## ADDENDUM NO. 1

**Date:** April 5, 2017

**Project:** Hall Elementary School  
Portland Public Schools/City of Portland  
Portland, Maine

1 UNDERSLAB PLUMBING PART PLAN A
 P-101 SCALE: 1/8" = 1'-0"

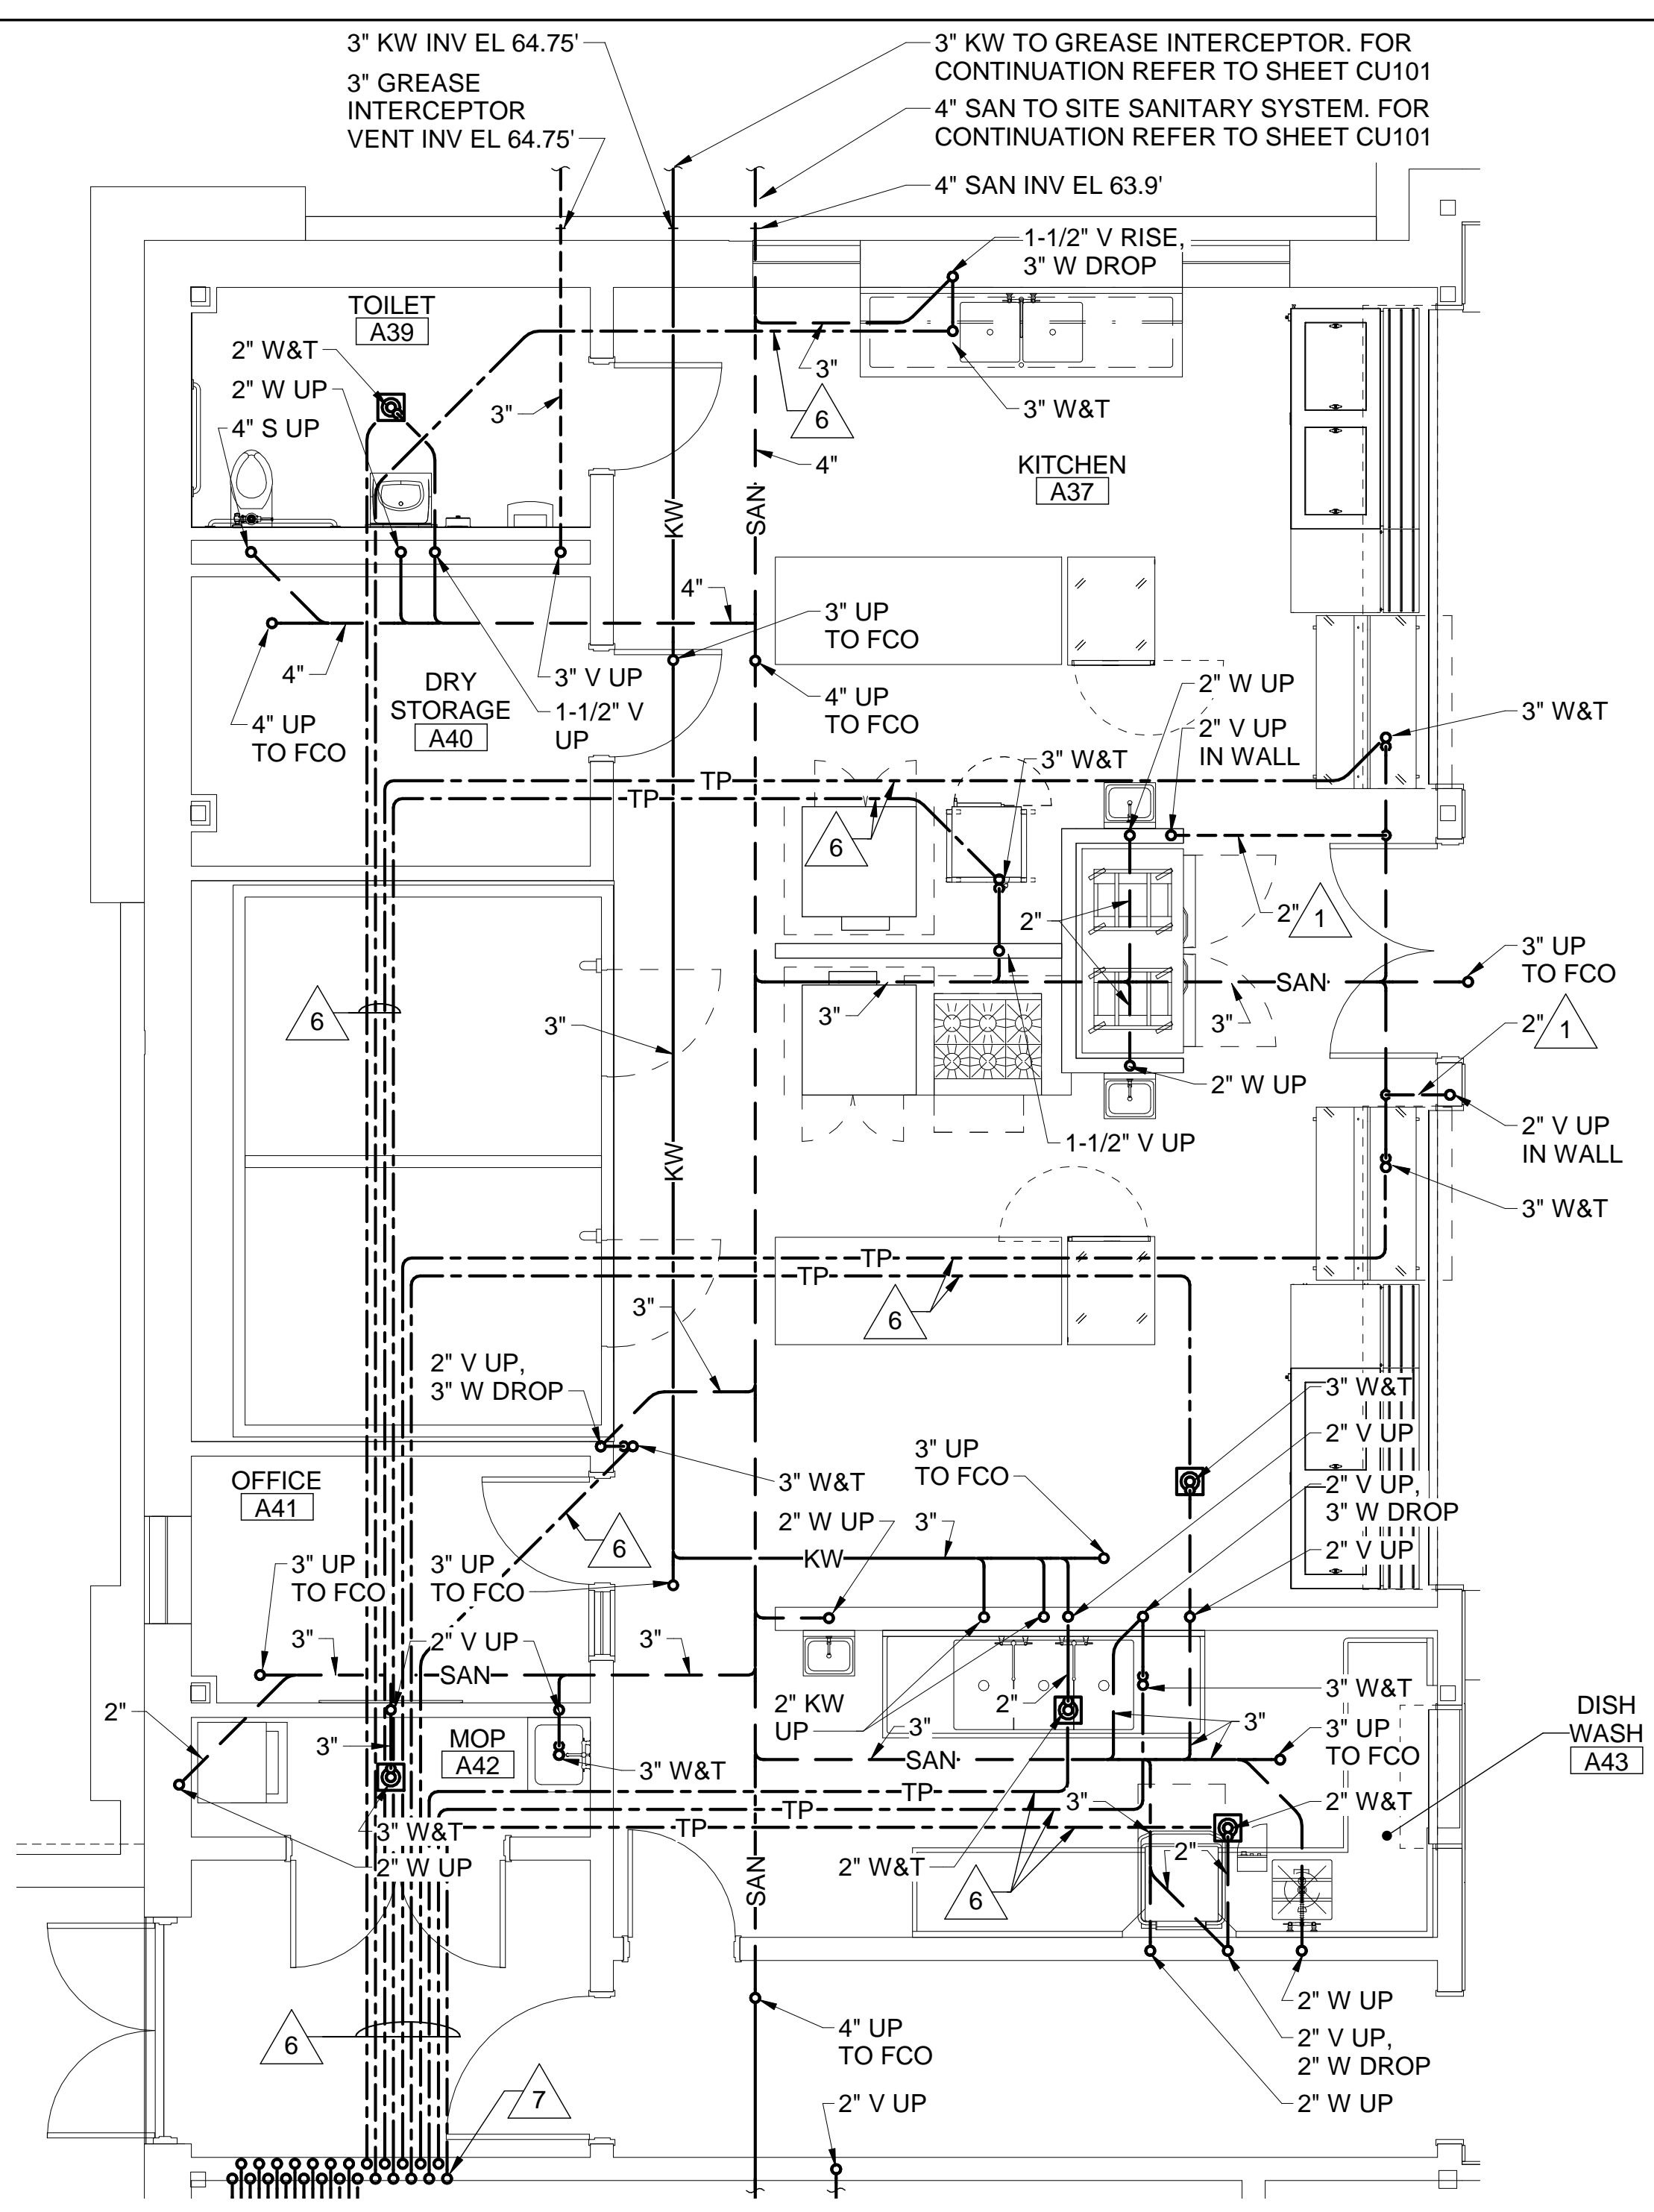
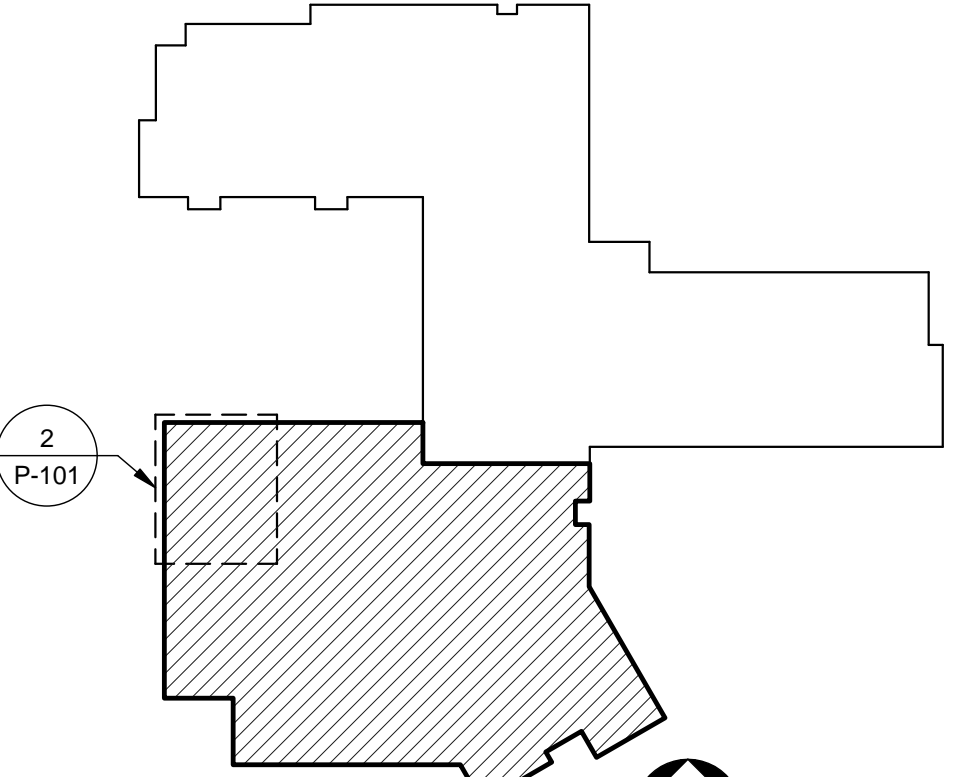
2. **DELETE** sheet in its entirety and **REPLACE** with attached sheet P-101. Missing pipe sizes have been provided throughout.

1 FIRST FLOOR PLUMBING PART PLAN A
SCALE: 1/8" = 1'-0"

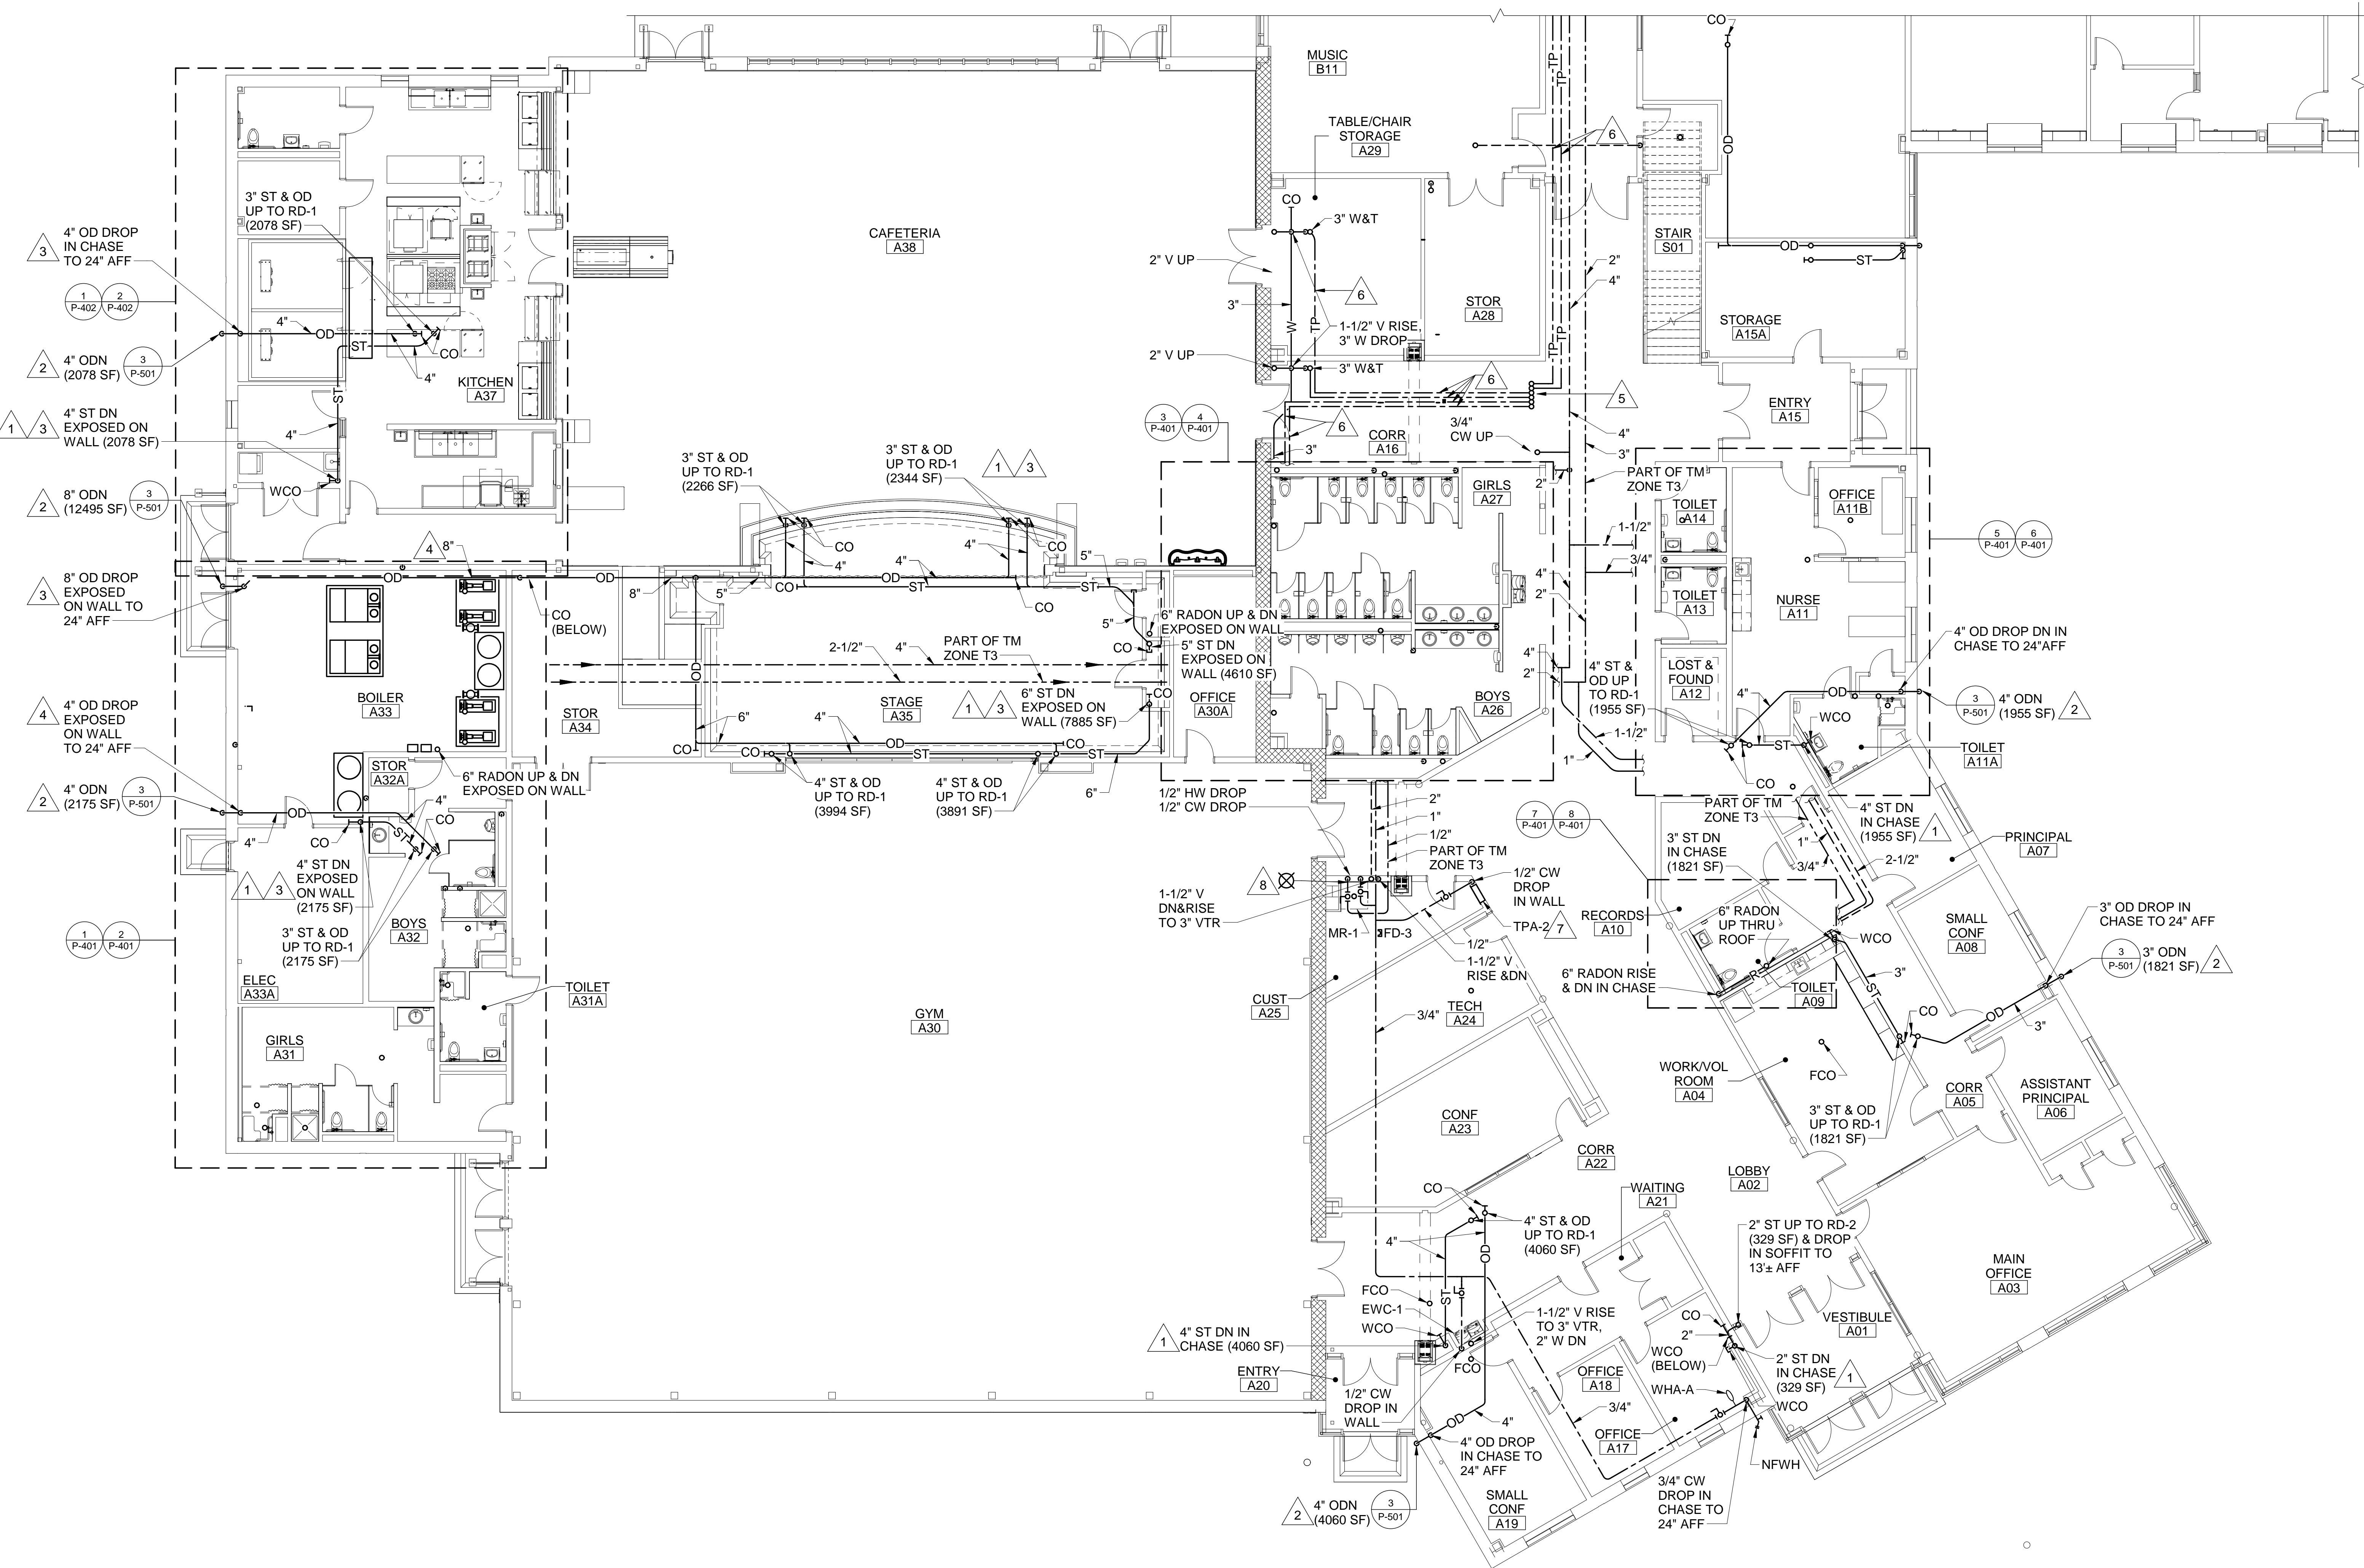
1. **DELETE** sheet in its entirety and **REPLACE** with attached sheet P-104. Missing pipe sizes and temperature maintenance zones have been provided throughout.
